**KIRKLEES METROPOLITAN COUNCIL
INVESTMENT & REGENERATION SERVICE**

**DELEGATED DECISION TO DETERMINE APPLICATIONS FOR
NON-MATERIAL AMENDMENTS**

Reference No: **2023/NM/91167/E**

Site Address: 14, Thornhill Park Avenue, Thornhill, Dewsbury, WF12
0DA

**PROPOSAL  
PROPOSED REAR EXTENSIONS**

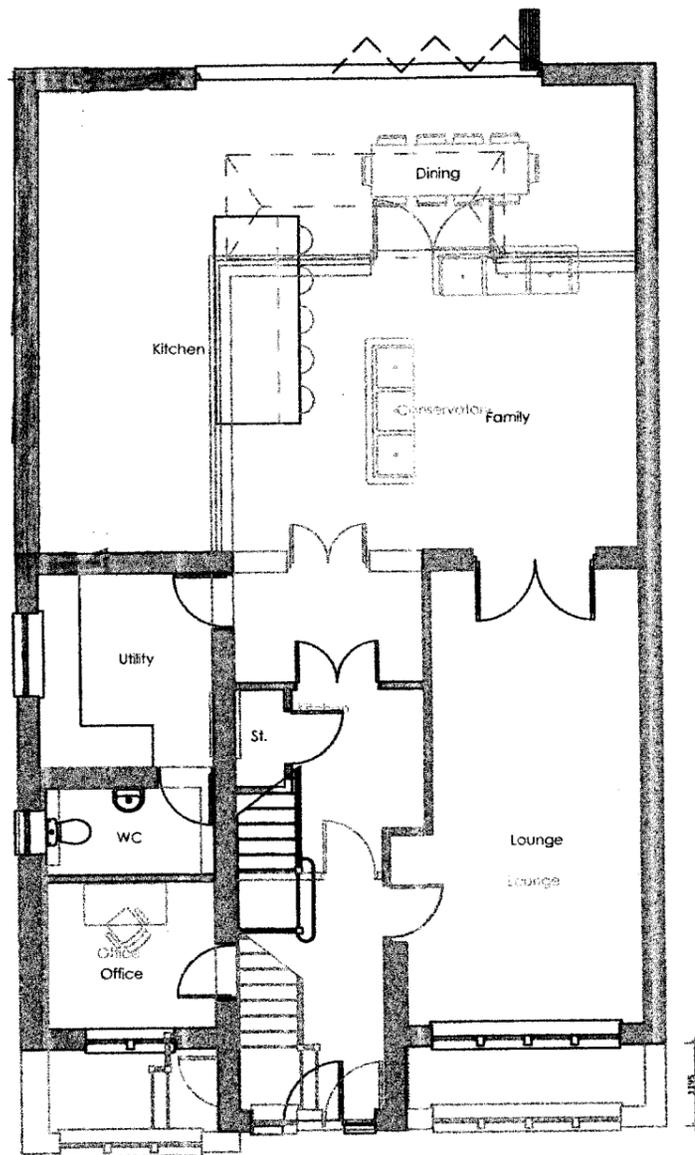
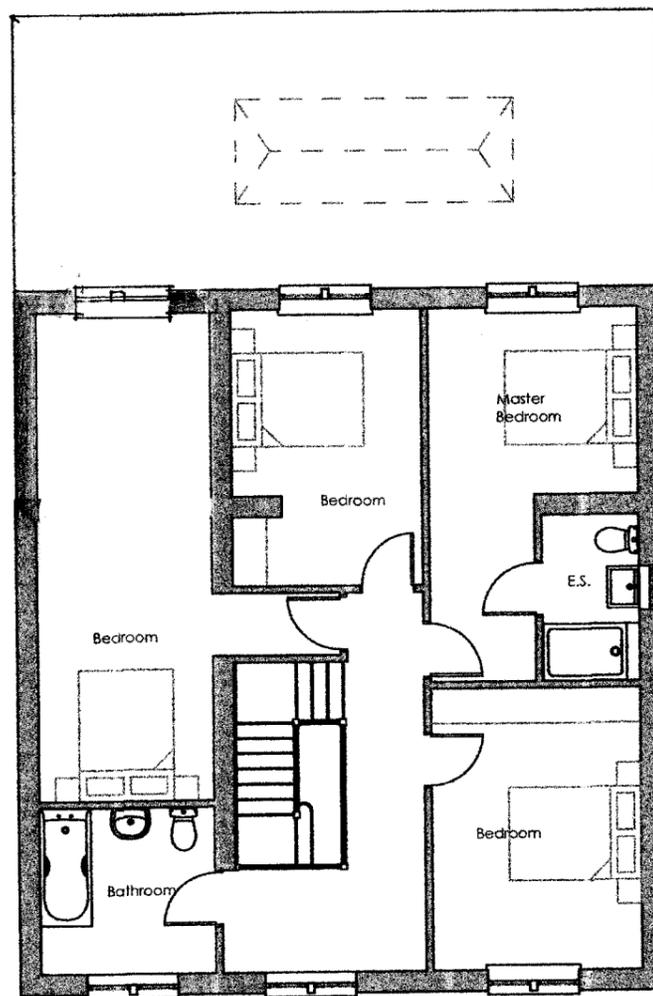
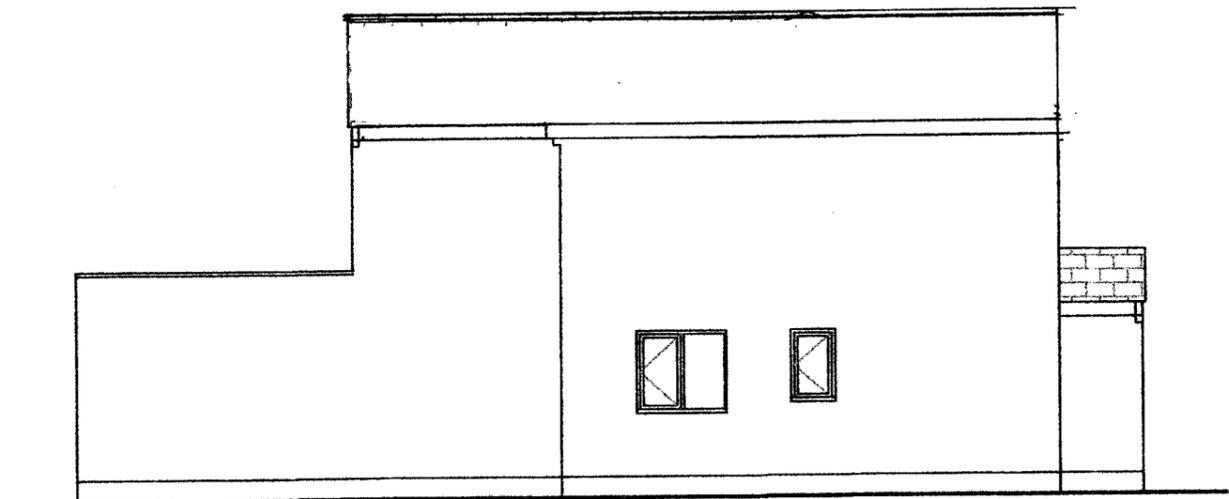
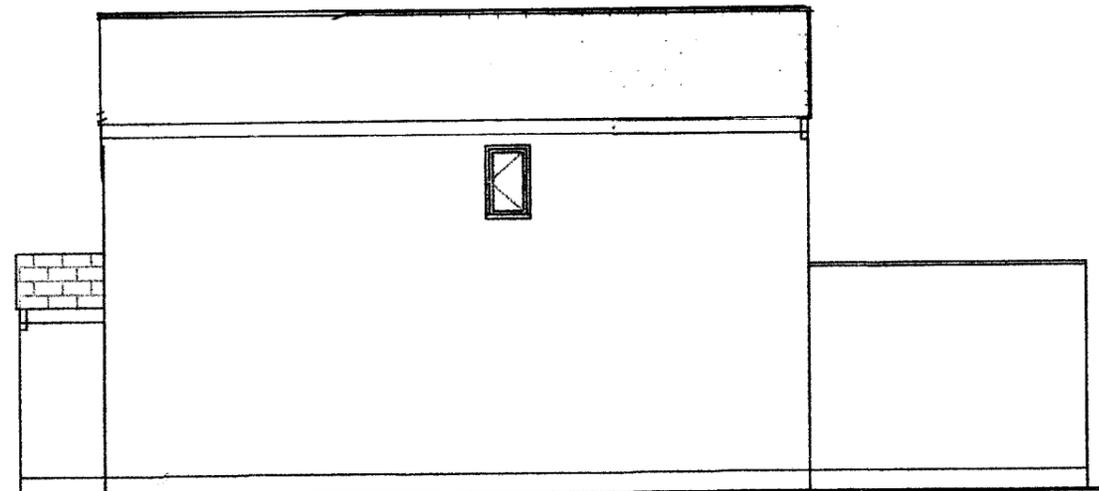
The submitted plans and application form indicate that the non-material amendment being sought for a gable wall to front elevation and widening of ground floor and first floor extensions.

The proposed amendment would significantly increase the scale of the approved ground floor and first floor rear extensions. Therefore, the amendment would be consequential in terms of scale in relation to the original approval.

The proposed amendment would add significant mass to the north elevation which would be in close proximity to no.14a which has primary openings in the side elevation. As the proposal would change significantly in scale, it would have a detrimental impact upon the living conditions of the occupiers of neighbouring properties.

The amendments would not comply with LP24(c) which states, “extensions are subservient to the original building, are in keeping with the existing buildings in terms of scale, material and details and minimise impact on residential amenity of future and neighbouring occupiers”. The proposed amendment would not be in keeping with the scale of the existing dwelling.
